From: Patz, Logan W.
To: ["Eric Munn"](#)
Cc: [Al-Najjar, Marwa G.](#)
Subject: RE: NM Beef Jerky Restaurant, 1425 4TH St. NW J14D185 TCL Comment Letter
Date: Wednesday, August 09, 2017 4:33:00 PM
Importance: High

NM Beef Jerky Restaurant, 1425 4TH St. NW J14D185 TCL

SHEET
TCL
1 of 1
8-21-17
DATE
PROJECT NO.

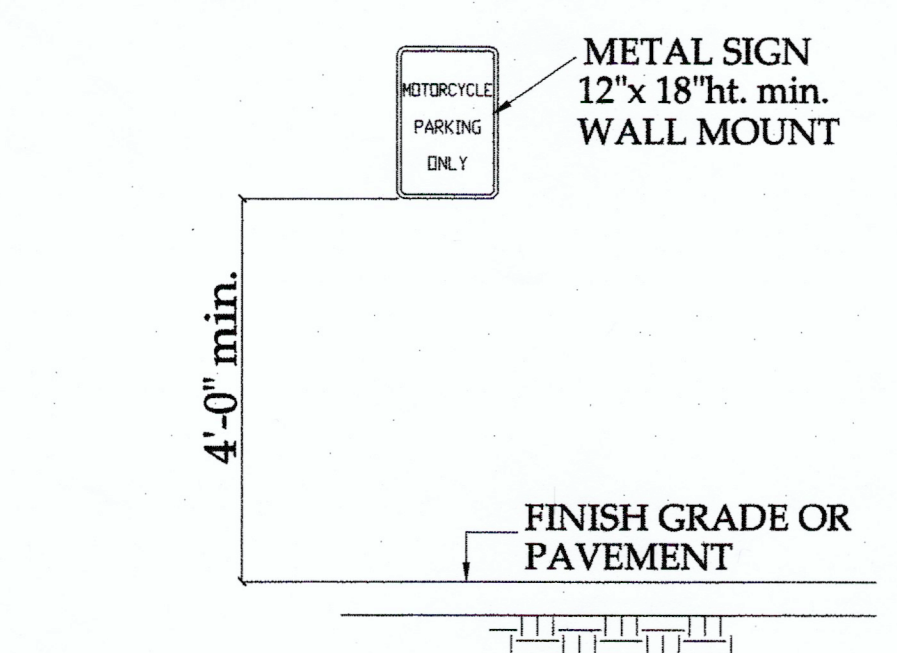
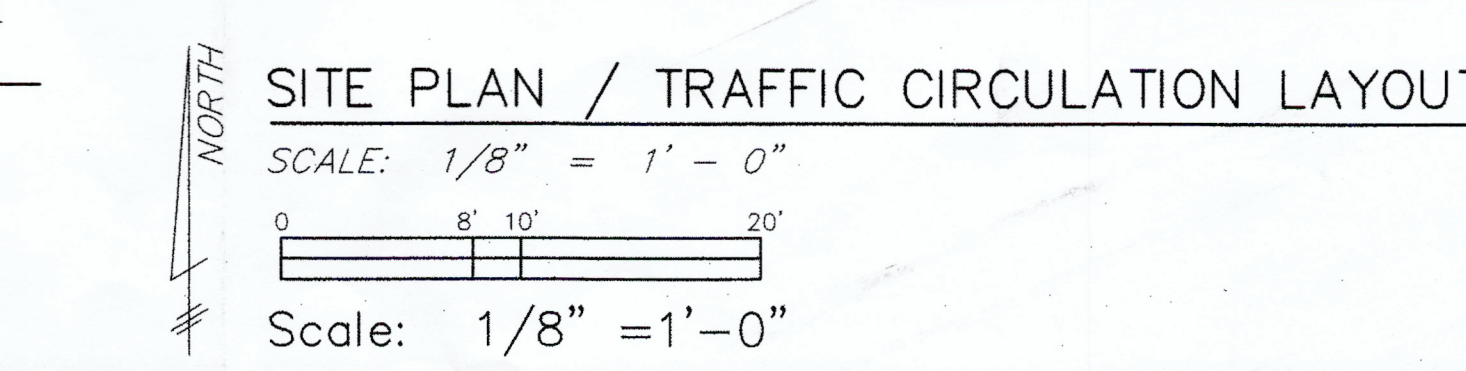
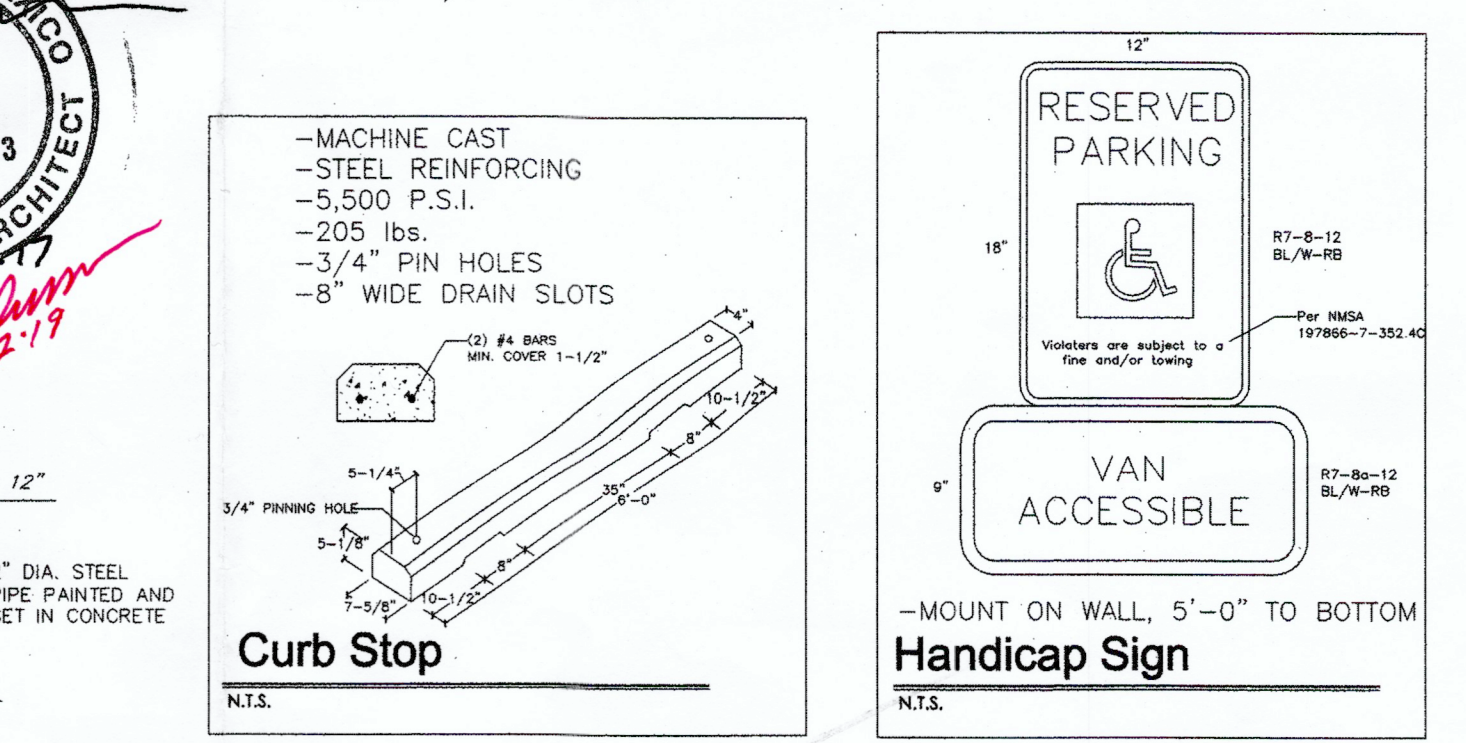
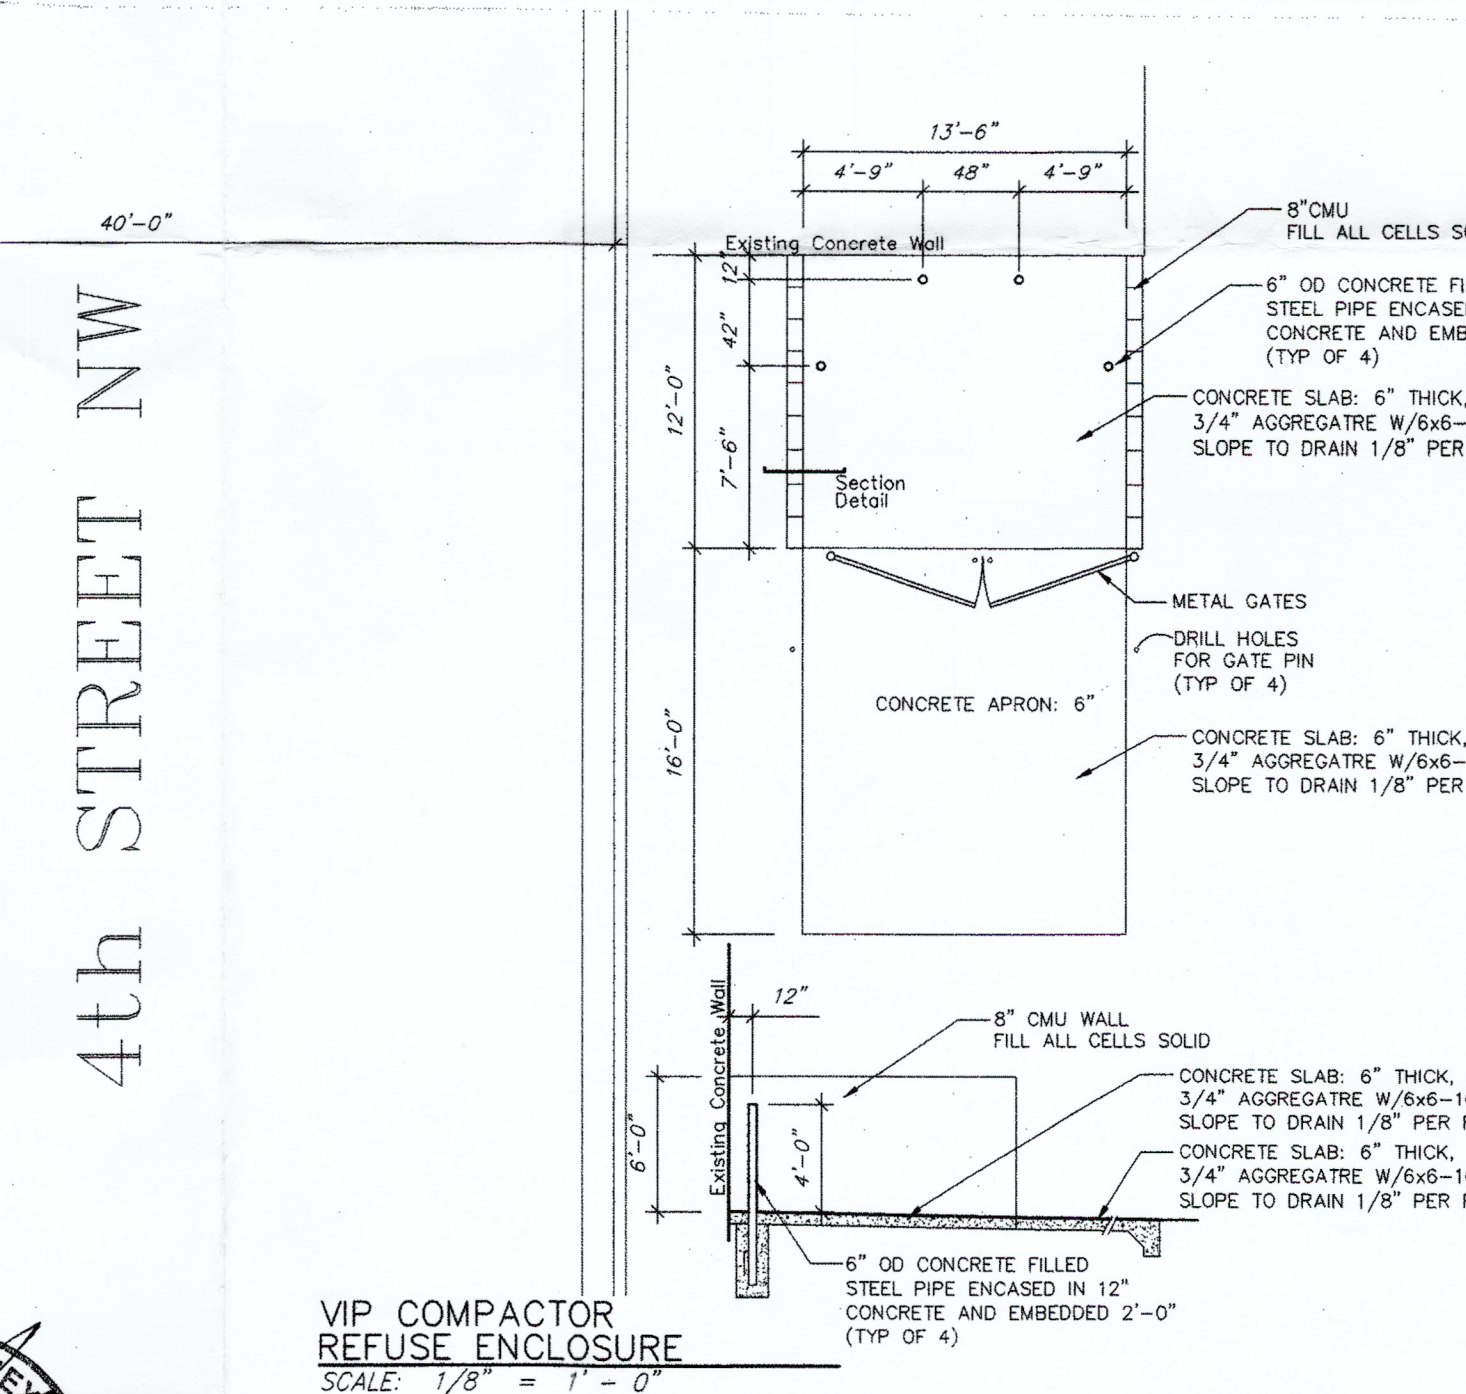
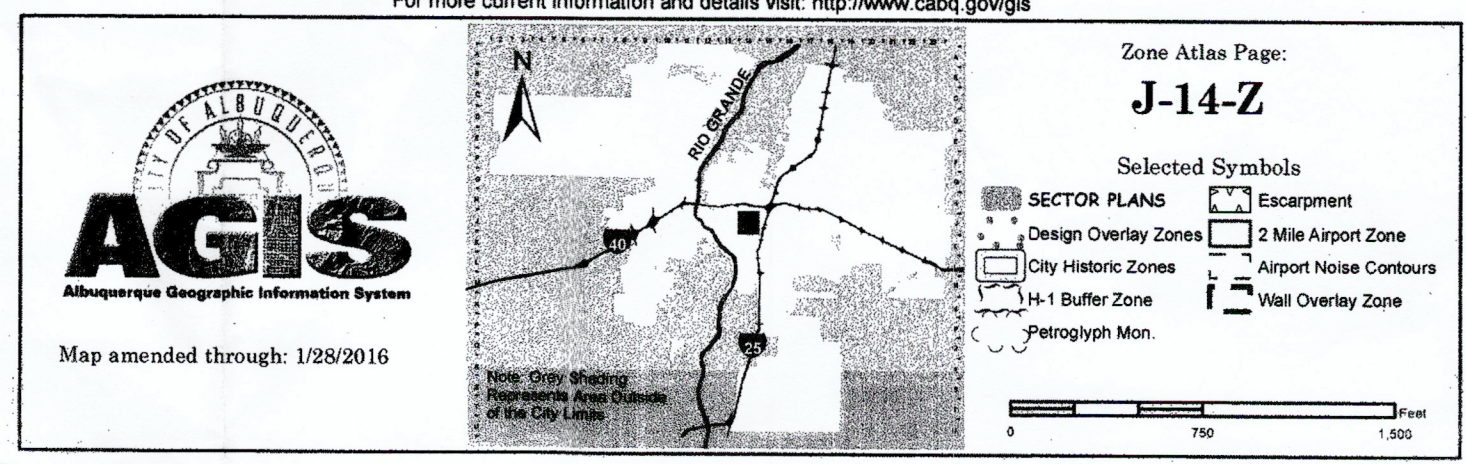
- We need dimensions on the Motorcycle parking spot.
- And the area where the bike rack is located will need to be striped. It looks too much like a parking spot.

TCL
1 of 1

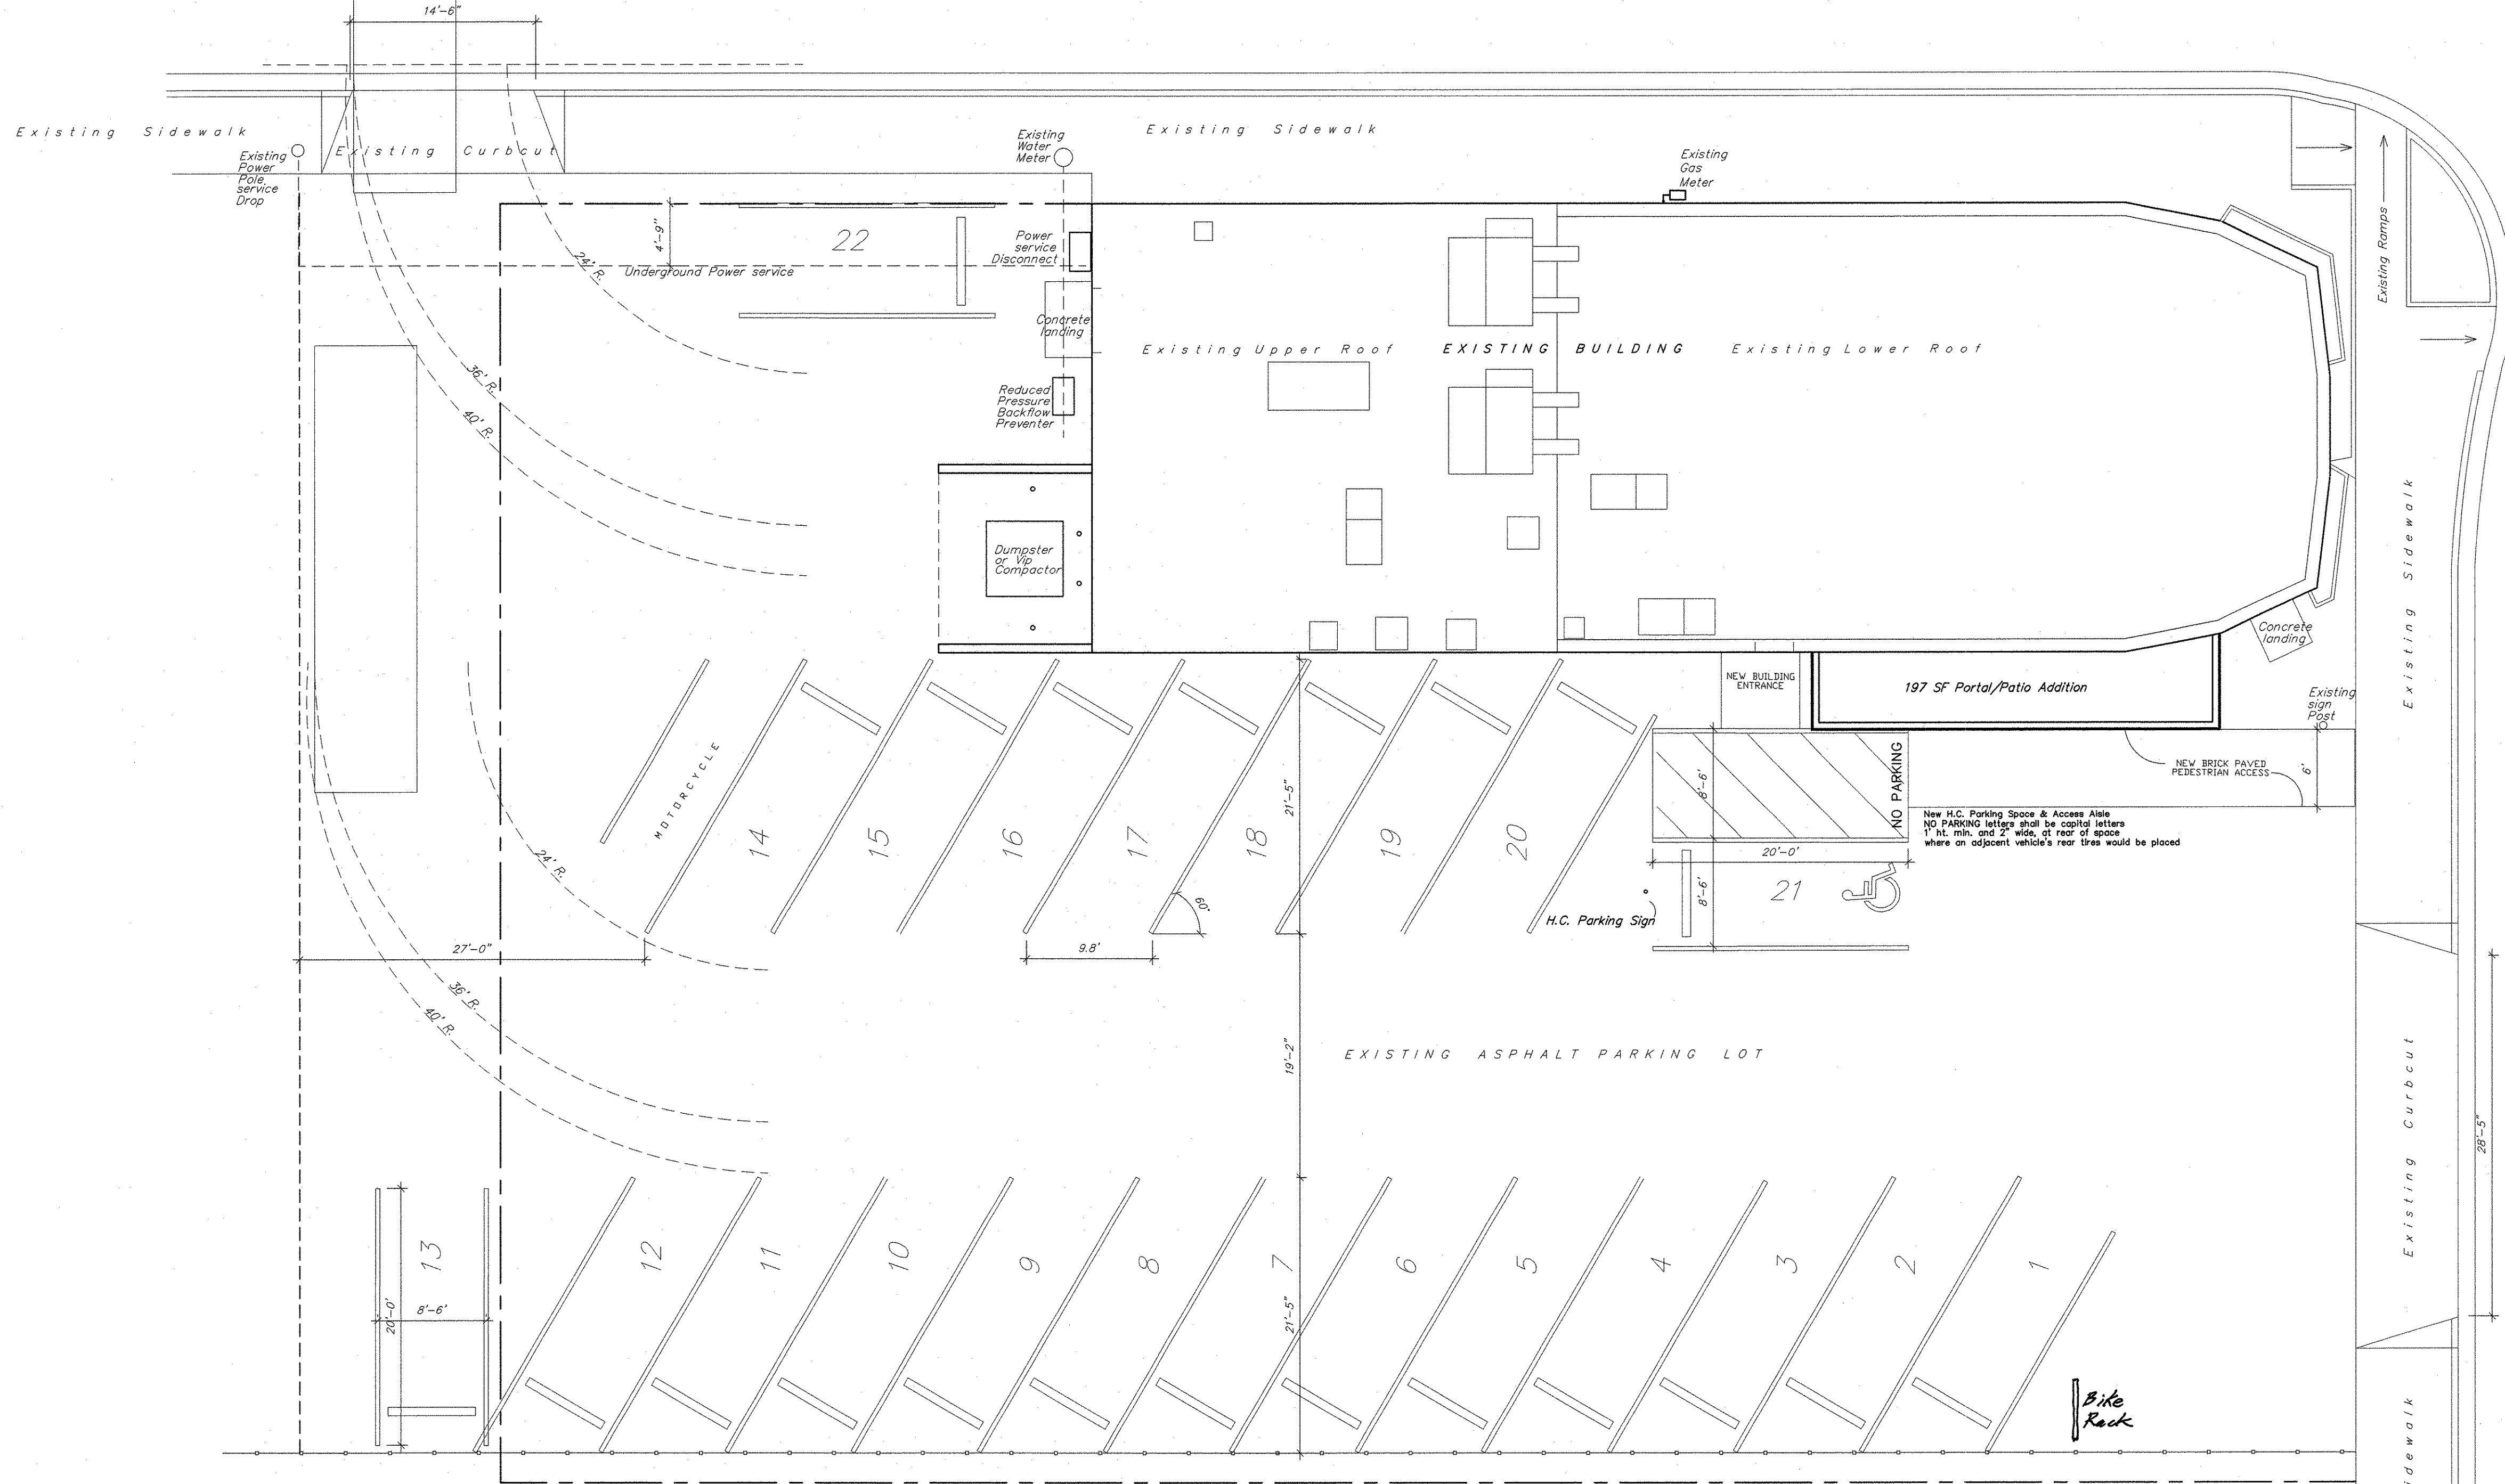
A Grading and Drainage plan will be needed if the dirt portion is paved and would require first flush ponds from my understanding. (you would need to talk to hydrology on that) One of the thresholds is an addition of 2000 SF of impervious surface. I talked to Shawn and I am unaware of a zoning code saying if the parking has more than 20 spots the lot must be paved. So it can stay gravel. The alley must be paved and will need to demonstrate that it drains properly to the street on the DRC plans. It may need cut-off walls if the whole lot is not paved.
